In reply please quote: 09/03134
Your Ref: SSD6078 MOD5

**SSD6078 MOD 5 - SECTION 96(2) MODIFICATION APPLICATION TO
WAREHOUSE AND DISTRIBUTION FACILITIES AT OAKDALE CENTRAL (LOTS
1C, 2B & 3) - FAIRFIELD CITY COUNCIL SUBMISSION**

Council is responding to a request by Goodman Property Services (Aust) Pty Ltd to modify the State Significant Development (SSD) application for the warehouse and distribution facilities at Oakdale Central Estate, Horsley Park being Lot 21 DP 1173181 (estate allotments 1C, 2B and 3 Oakdale Central).

Development Area Schedule	
Total Lot 3 Site Area	155,900 sqm
Warehouse	86,283 sqm
Office	1,000 sqm
Dock Office	190 sqm
Total Building Area	87,473 sqm
Site Cover (exc. awning)	56 %
Floor Space Ratio	0.56 : 1
Total Hardstand Area	43,415 sqm
Total Light Duty Area	12,774 sqm
Carparking	462

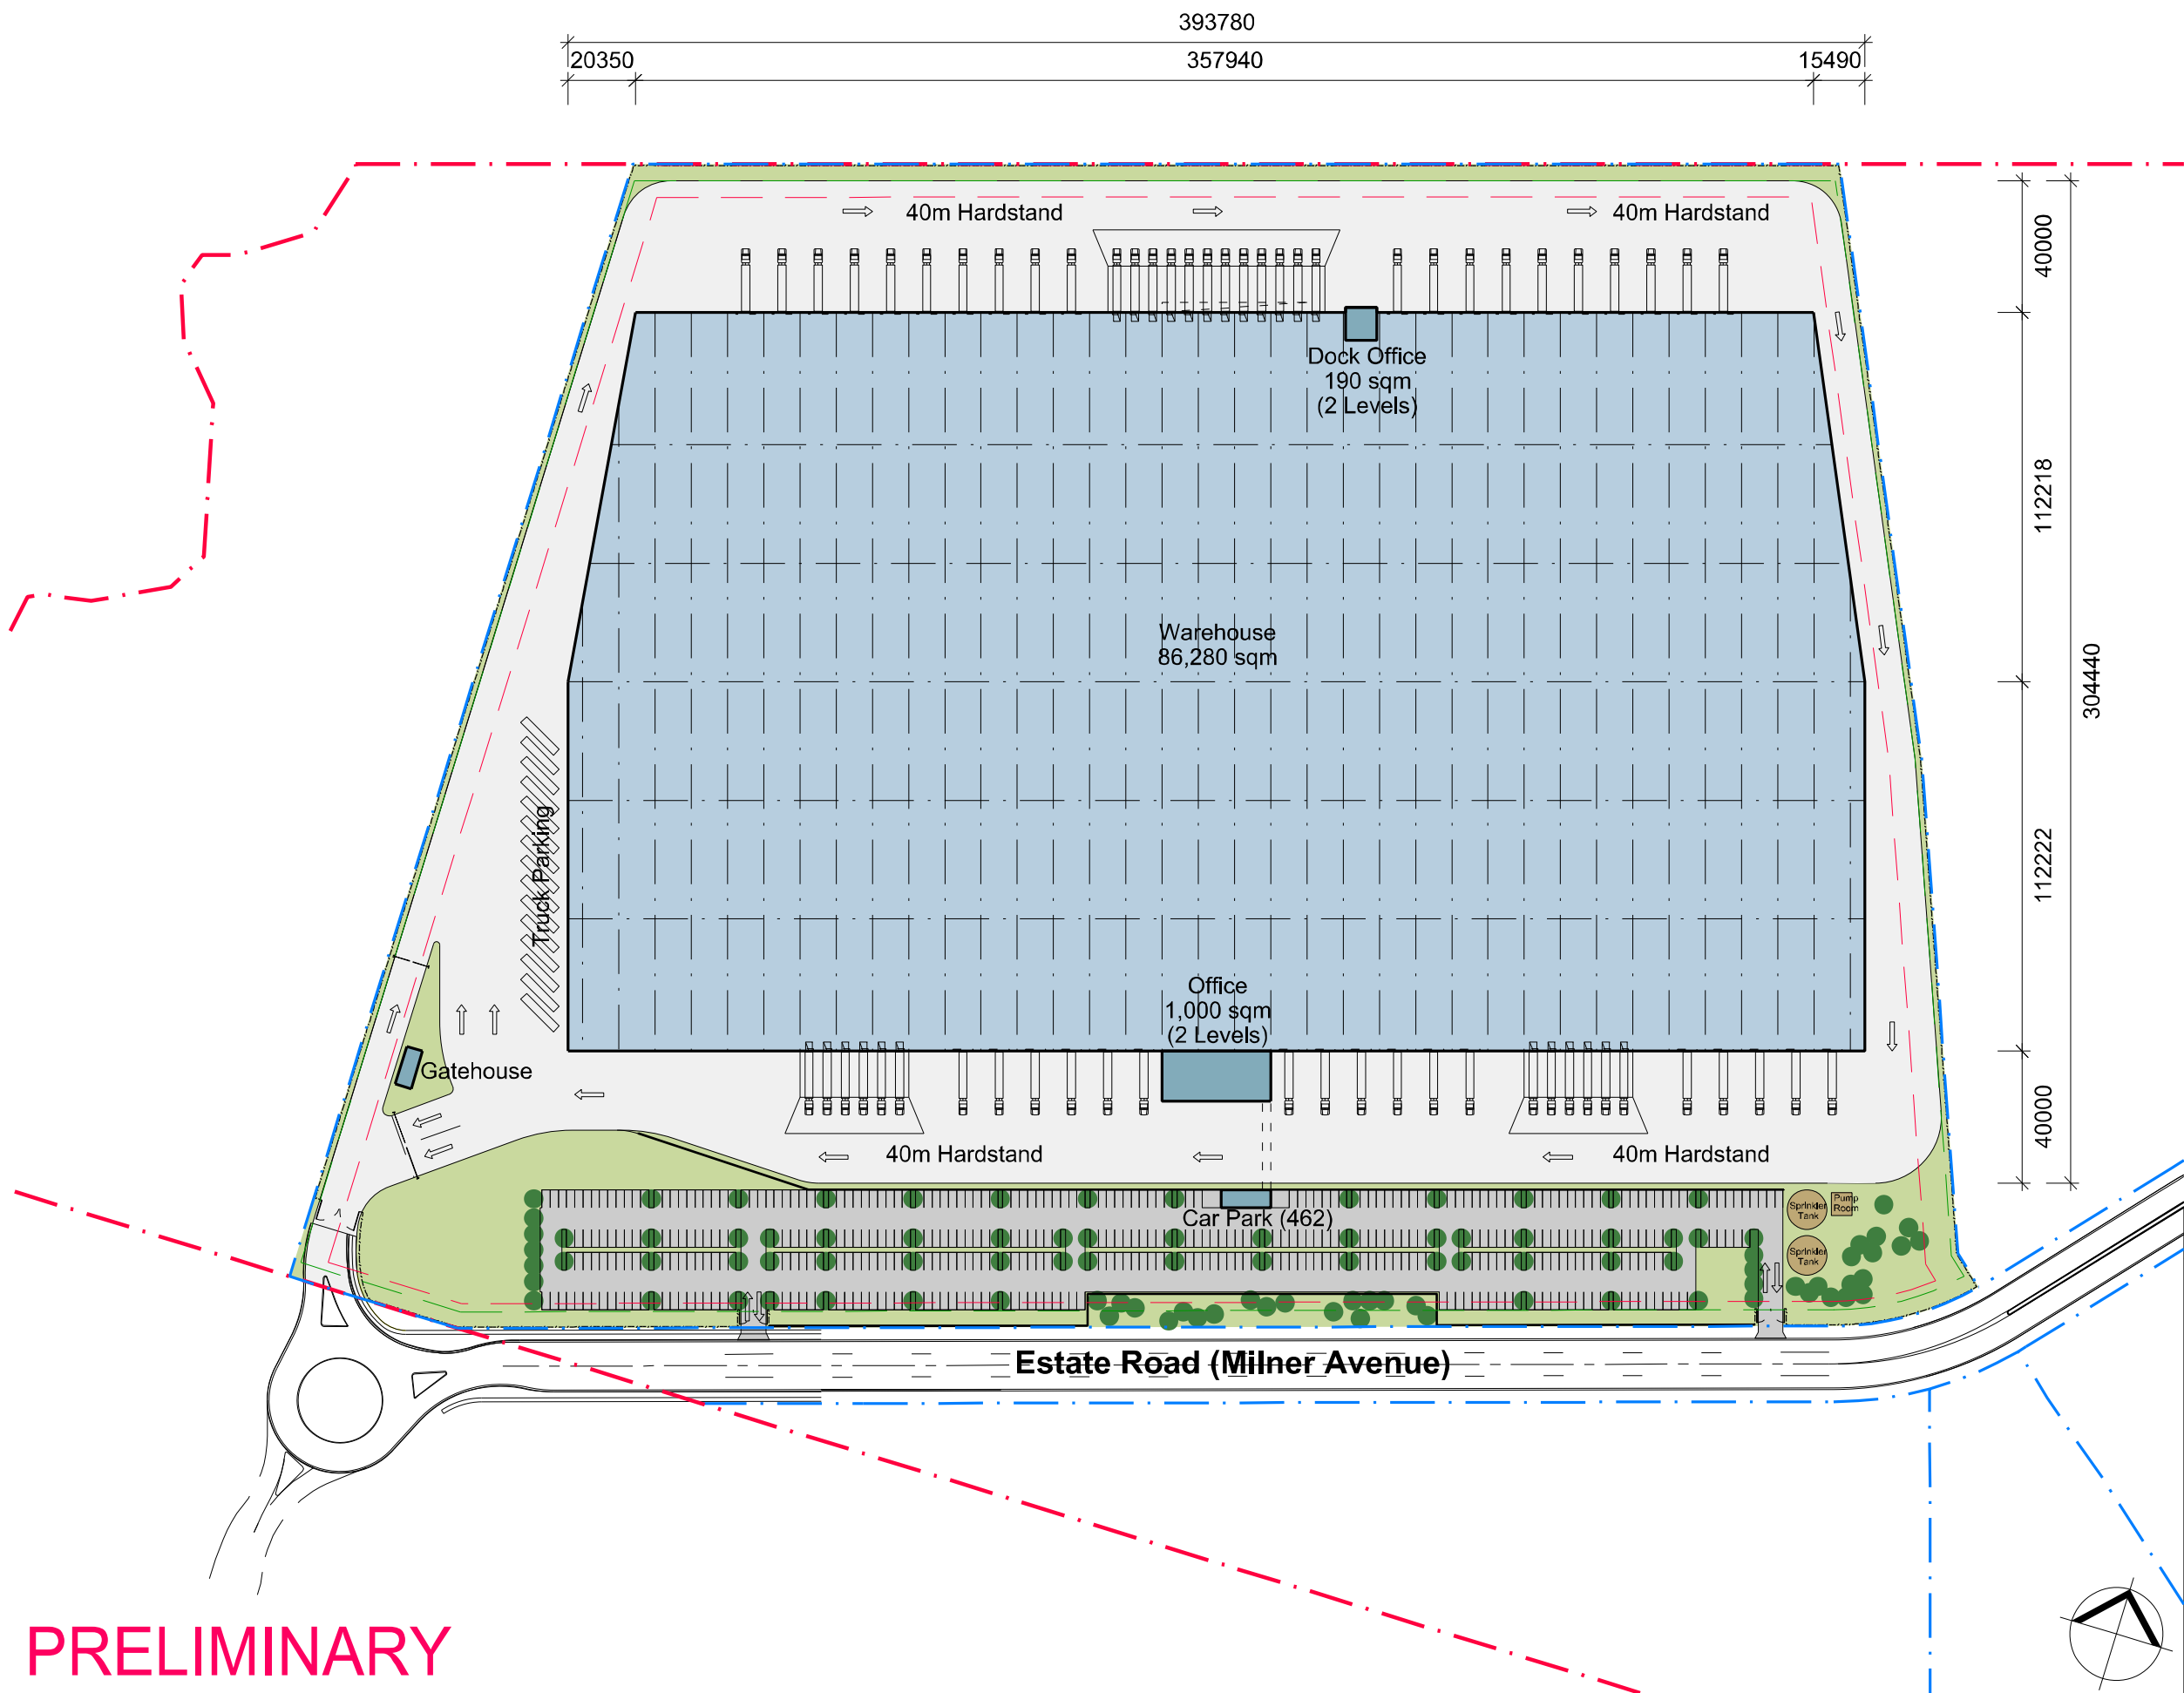
1. Warehouse 3C shall include a Right of Carriageway benefiting Lot 3B for use by commercial vehicles.
2. The servicing of warehouse 3A shall be restricted to 19m articulated vehicles and 3B, 3C and 3D could be serviced by 26m B-Doubles.
3. Security gates shall be sufficiently setback so that vehicles can queue on entry to each site without obstructing through traffic on the Estate Road.
4. The internal design of the proposed developments shall comply with AS2890.1 (2004) Part 1: Off-street car parking, AS 2890.2 (2002) Part 2: Off-street commercial vehicle facilities and AS2890.6 (2009) Part 6: Off-street parking for people with disabilities.
5. A minimum clear height of 4.5m shall be provided within all areas traversed by service vehicles.
6. A minimum bay width of 3.5m shall be provided for all service bays.
